DRB Application No.: 07DRB-00587 (P&F)
Project Name: TOWN OF ATRISCO GRANT, UNIT 8
Agent: Jack's High Country

Project Number 1005544

**PLAT OF**  
**LOTS 263-A-1, 263-A-2 and 263-B-1**  
**TOWN OF ATRISCO GRANT, UNIT 8**  
WITHIN  
PROJECTED SECTIONS 11 AND 14  
TOWN OF ATRISCO GRANT  
TOWNSHIP 10 NORTH, RANGE 2 EAST, N.M.P.M.  
CITY OF ALBUQUERQUE  
BERNALILLO COUNTY, NEW MEXICO  
MARCH, 2007

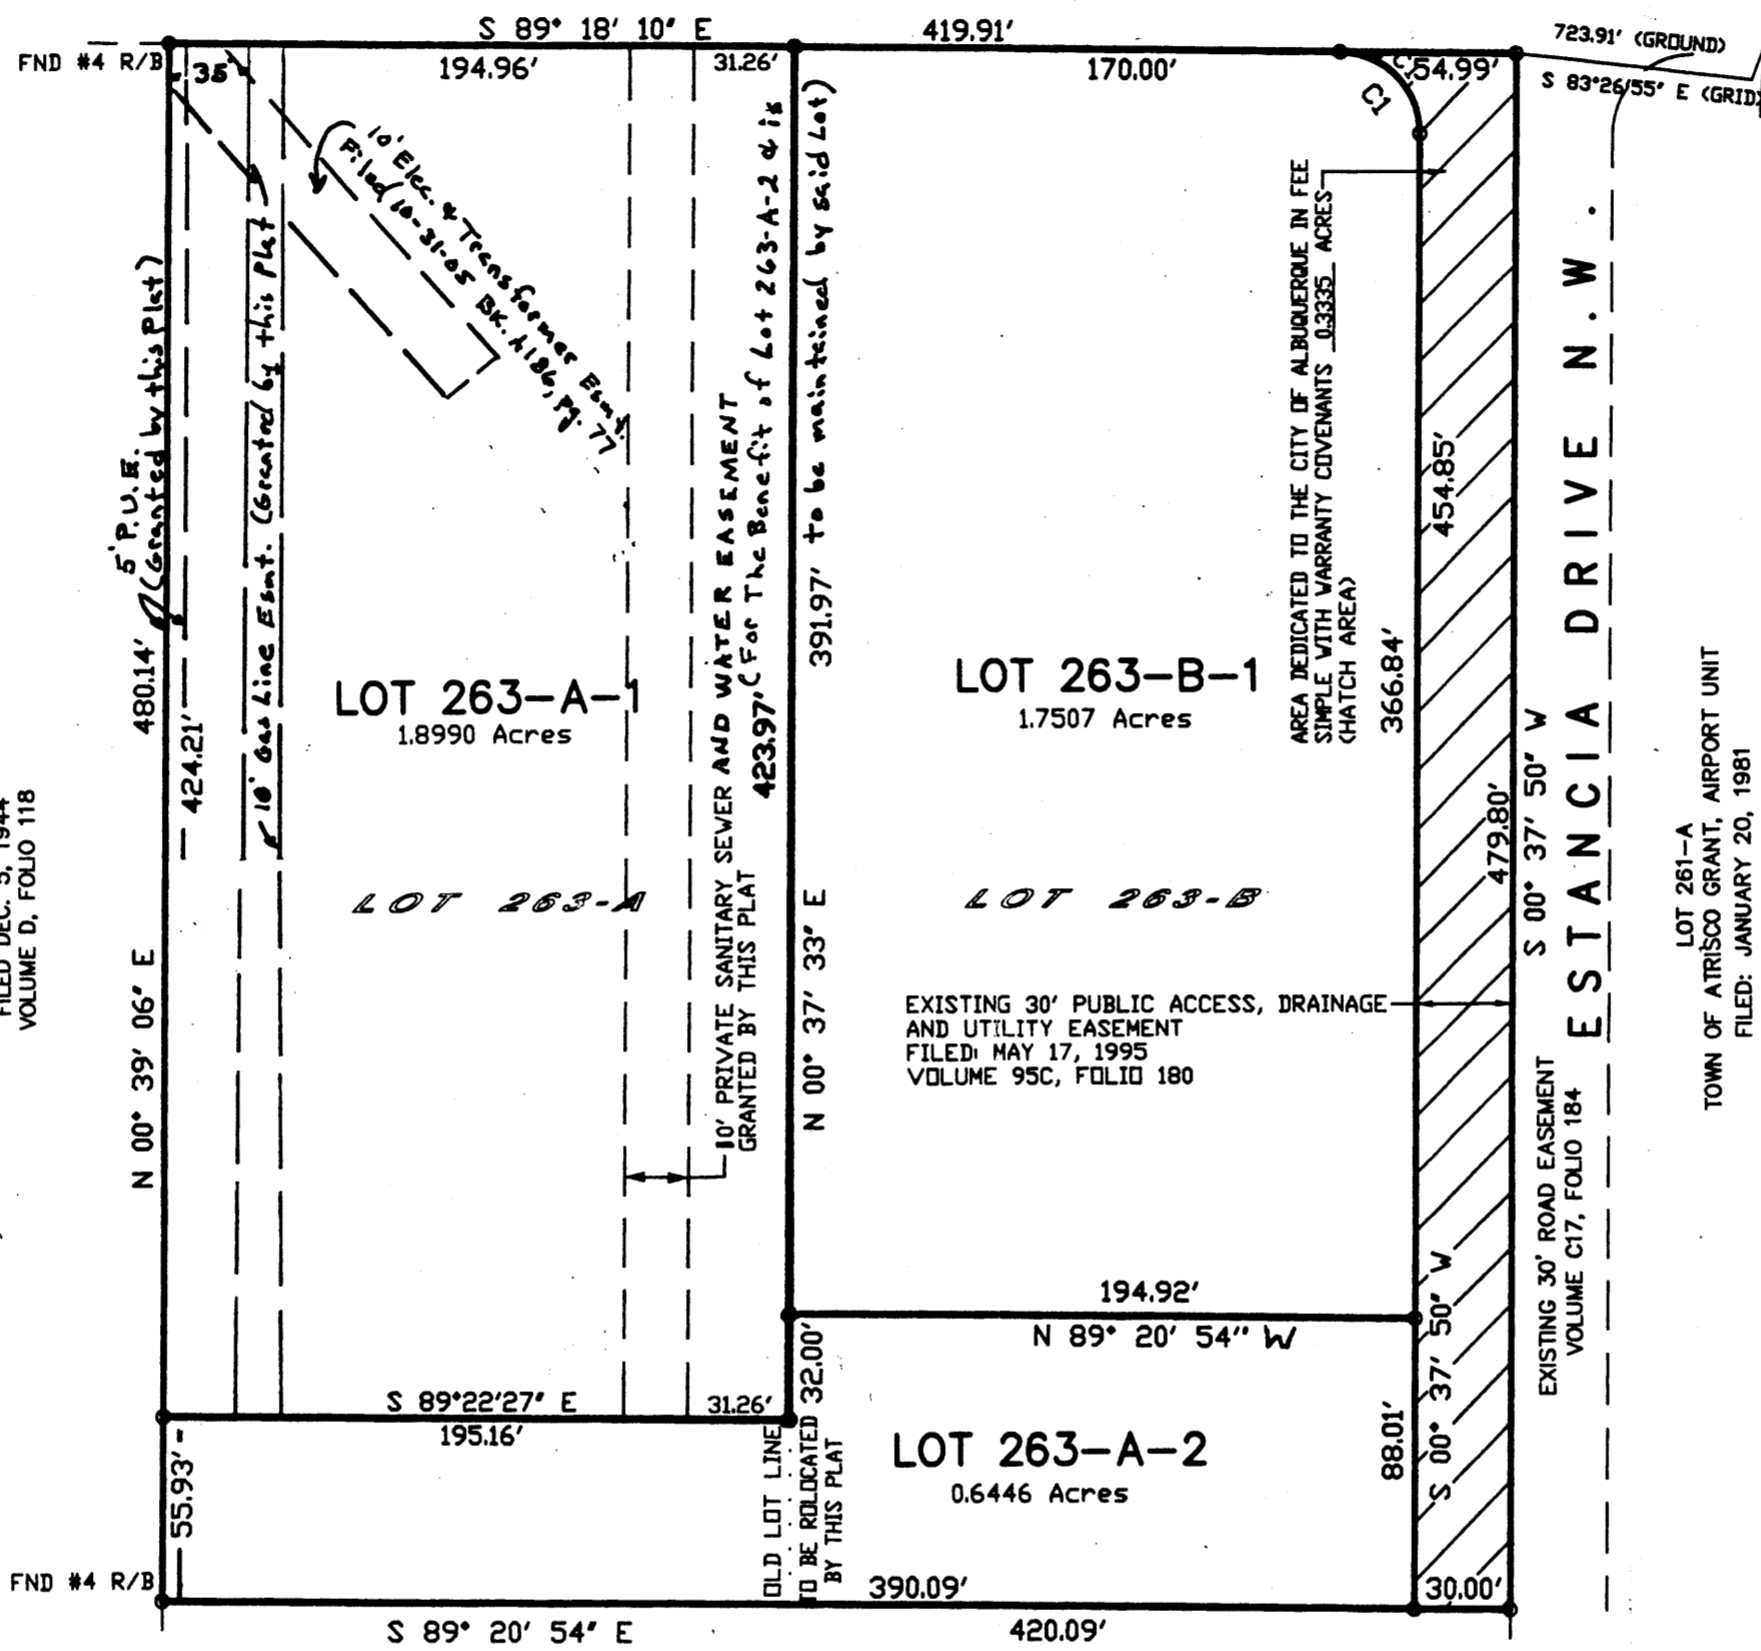
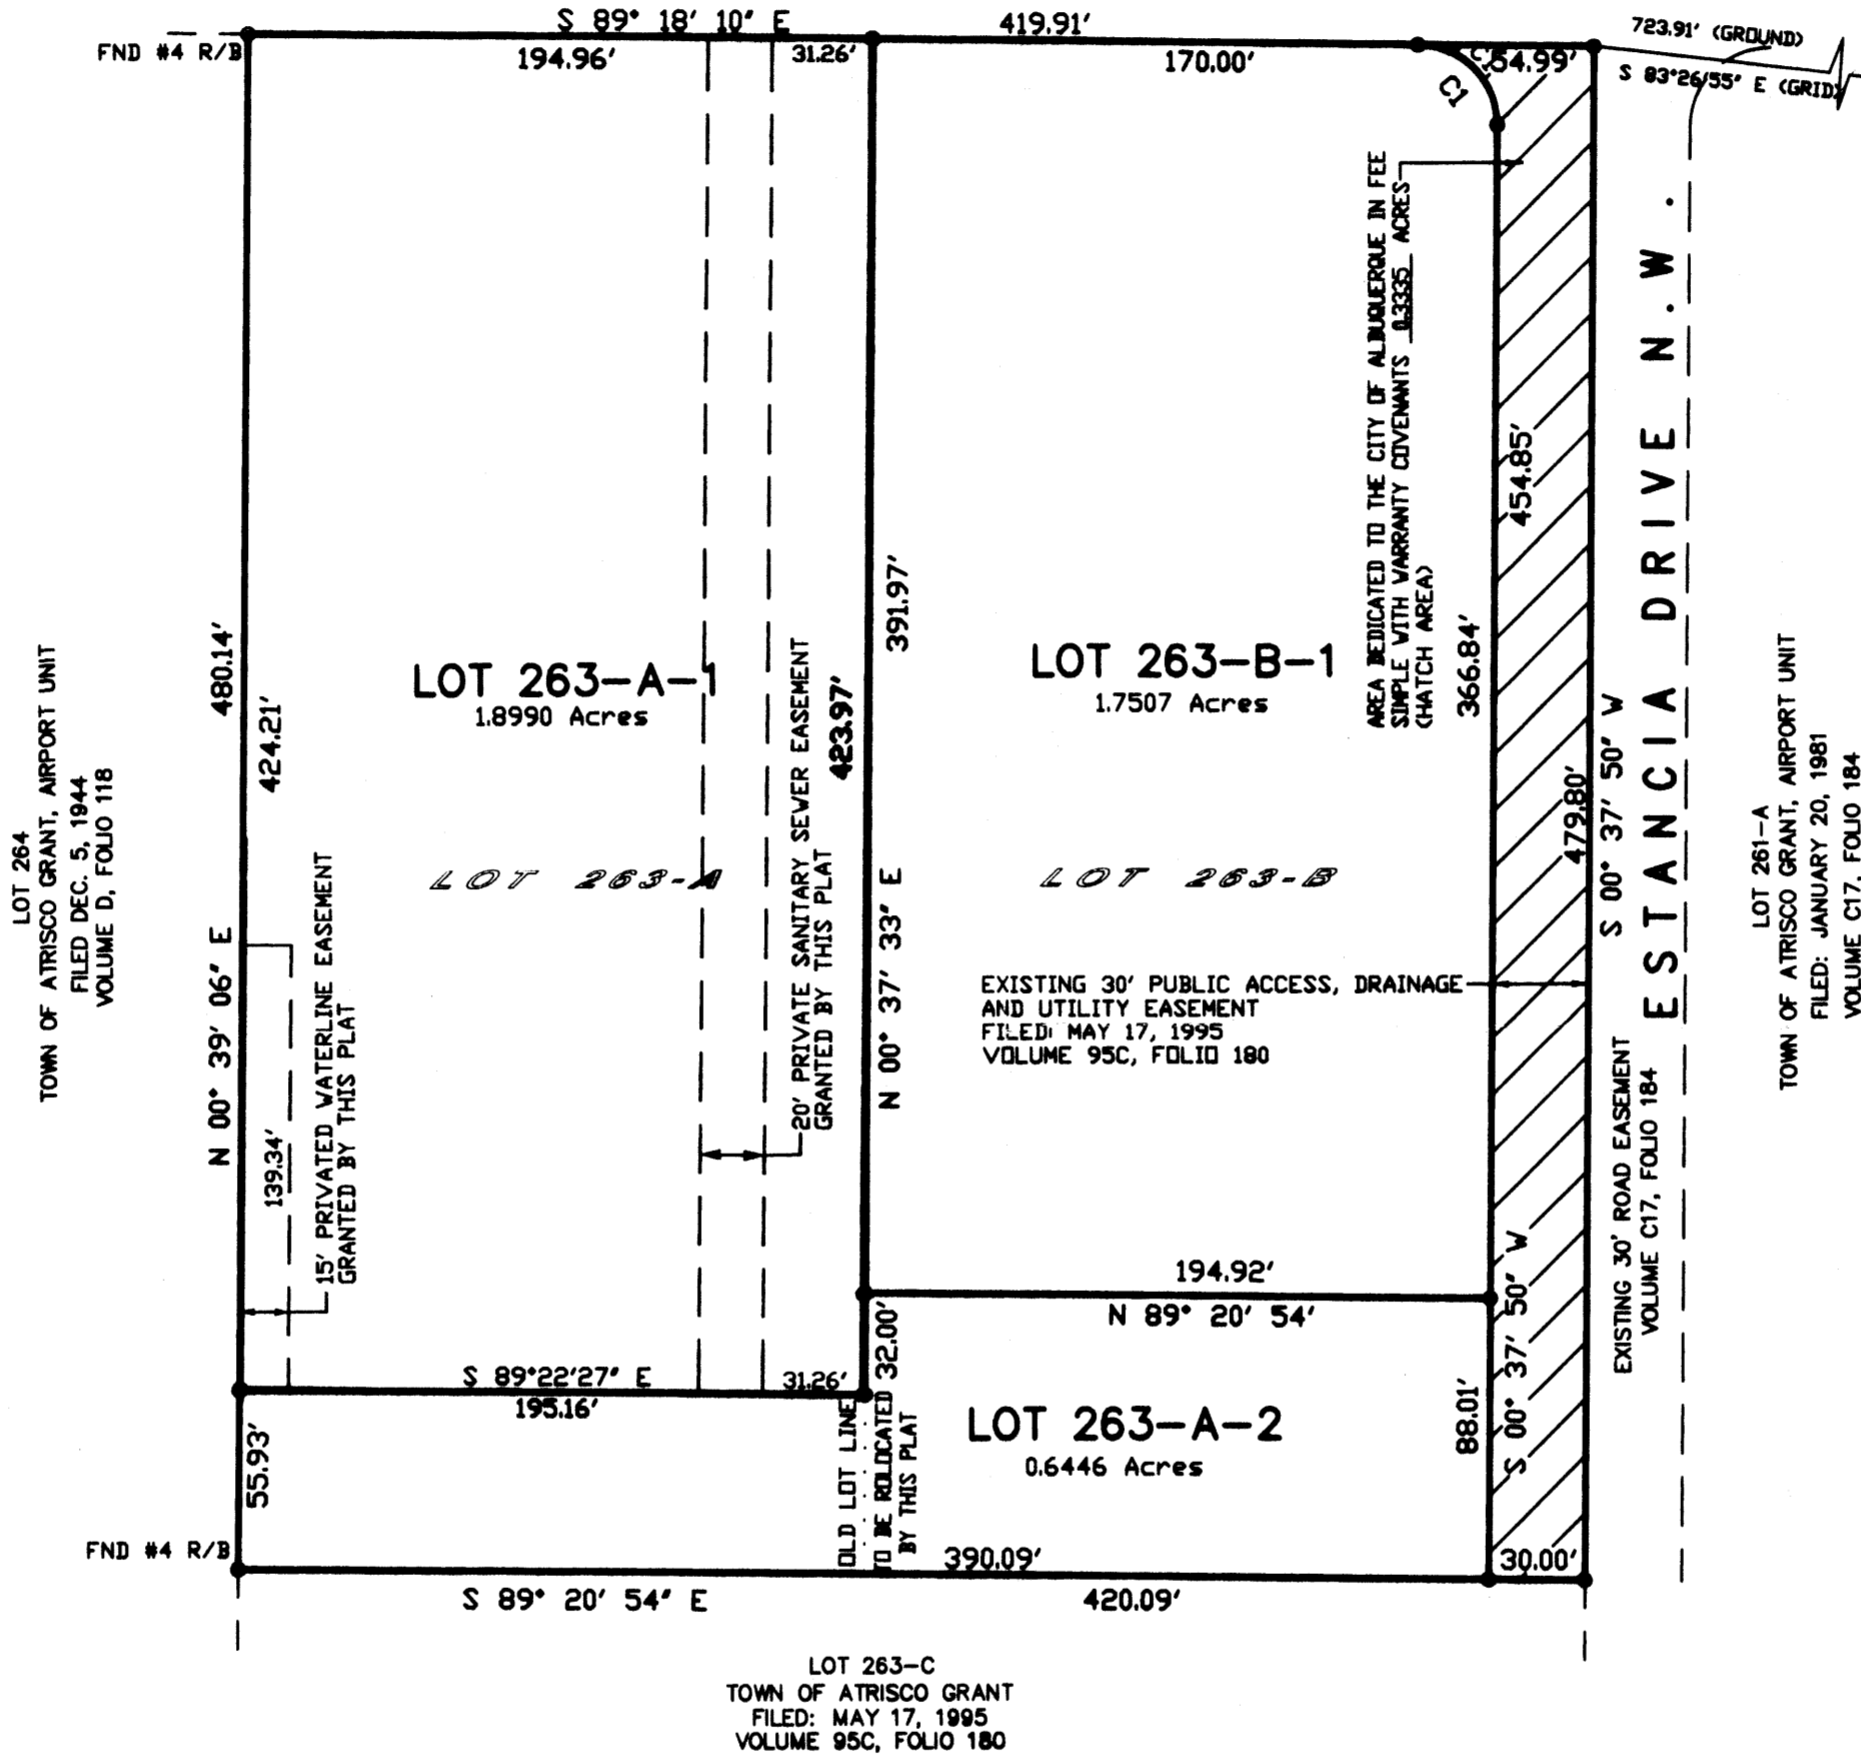
UTILITIES: proper w/ ^(private) SAs esmts and addition of Public
life easement

CITY ENGINEER / AMAFCA: record
private drainage esmts

A cross lot drainage easement is required.

| | 1) Cross sections of all streets are needed to evaluate infrastructure requirements. |
| | 2) Is the curb and gutter and sidewalk in place along both streets? |
| | 3) Coordination with Department of Municipal Development Transportation is needed to ensure that the Estancia alignment is still valid and whether dedication should be accepted. |
| | 4) Does the Estancia easement continue further south? |
